From: Email Services [REDACTED]
Sent: 16 December 2018 19:00
To: Zac Denton
Subject: 13 Norfolk Road, Littlehampton. BN17 5PW. Ref; LU/247/18/HH

SOUTH ELEVATION Drg no 2018/MEL/04A Aug 2018 Scale 1:50@A3

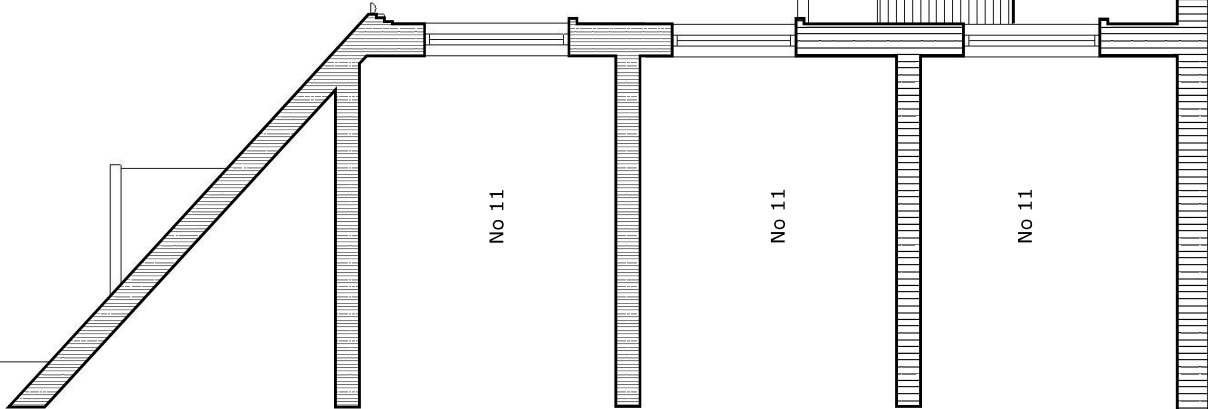
At the weekend we took the opportunity to re-assess the new proposed extension wall height of 2.8 metres and 4 metres in length.
The vision of this huge wall in a tiny space is daunting, being that it would be only inches away from the rear window to our one and only living area and only 1 metre away from our back door into the kitchen.
